New Lot

Address: Split from 218 Washington Ave.
* new address is 210 Washington Ave.

CHECK-LIST AGAINST ZONING ORDINANCE

Proposed Use/Work - build new single family home.

**1** **SITE PLAN**

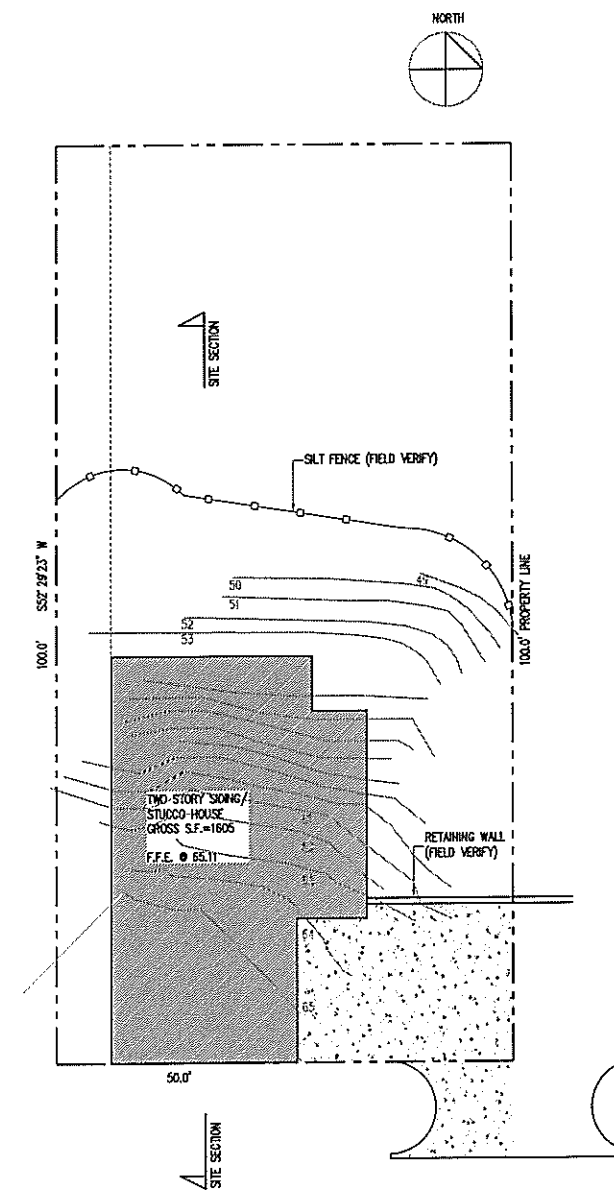
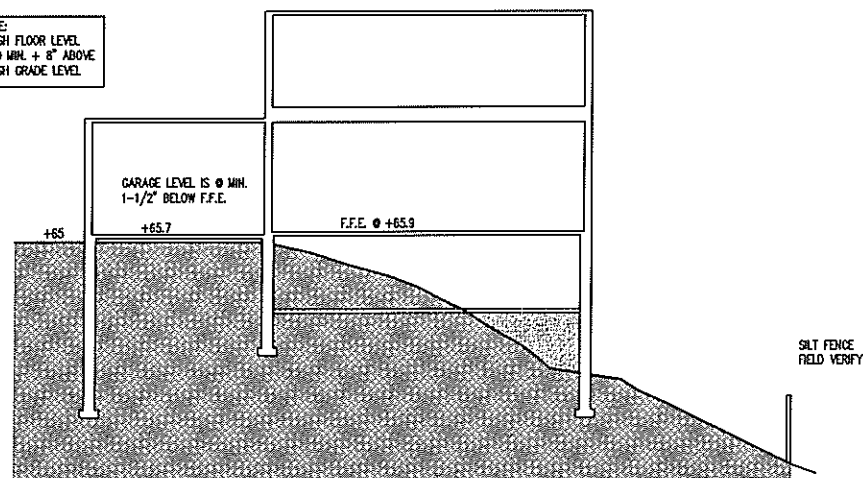
Lot Street Frontage - 50' min. ~ 50' given (OK)

Front Yard - max 10' or average (average) 15' (OK)
16' given 202 Washington = 3'
218 Washington = 0' average = 15'

Side Yard - 10' if lot for residential use - 202 Washington is single family - 218 Washington is lot for
* - left side - ~~10' or 15'~~ - 16' or 15' OK
OK 10' or 15' on right

Height - 45' max - OK scaled from top of roof to lowest grade - 35.25' (OK)

Lot Coverage Impervious Surface - 90% (OK)

garage footprint = 980
pavement = 7.5 x 15 = 112.5

Off-street Parking - 1 space required - 1 car garage (OK)

1549.5 sq ft / 5000 = 30.9% (OK)
